**Project # 1002851 & 1003026 Application # 04-01194 & 01195**

**RE: La Plaza Acequia 1 & 2/final plat**

**PROJECT # 1003026      APPLICATION # 04-00972**

**RE: La Plaza Acequia II/final plat**

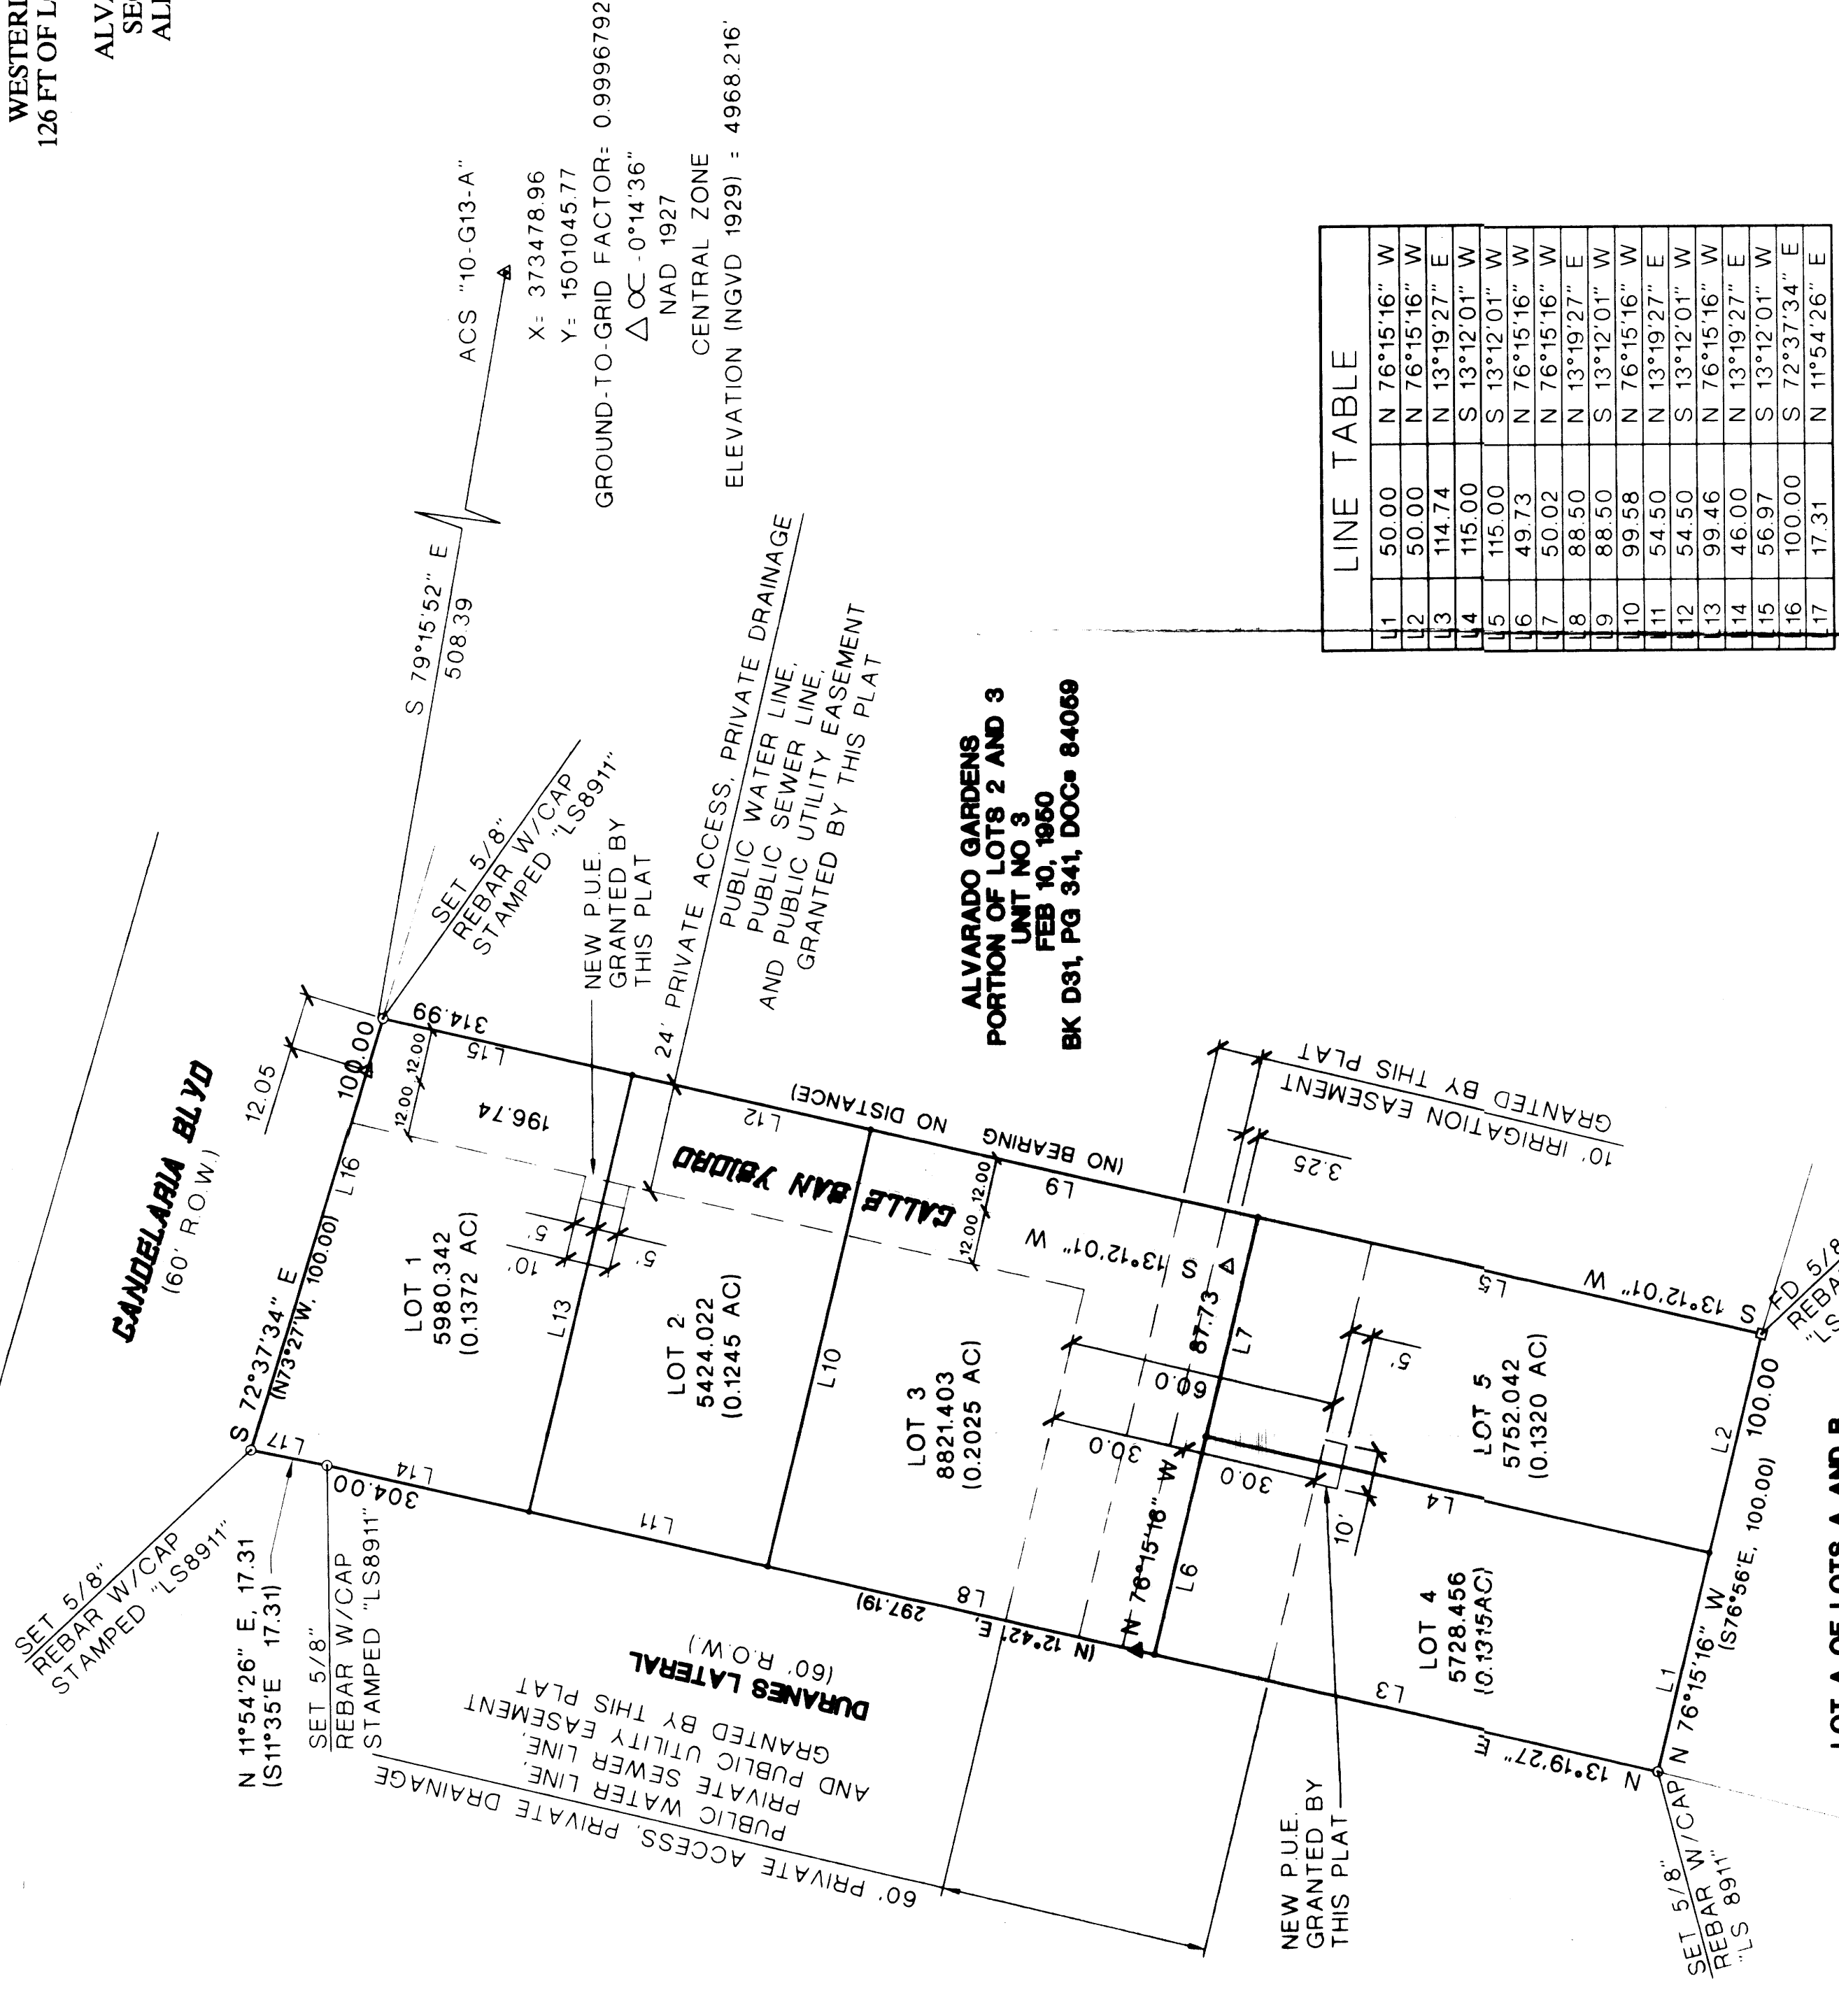
Has the condition of final plat been satisfied? "Public water & sewer easements will be separate from the PUE."

Is there any difference between the preliminary & final plat?

This language must appear on the final plat above the owner's signature:  
"Said owner warrants that he holds complete & indefeasible title in fee simple to the land subdivided."
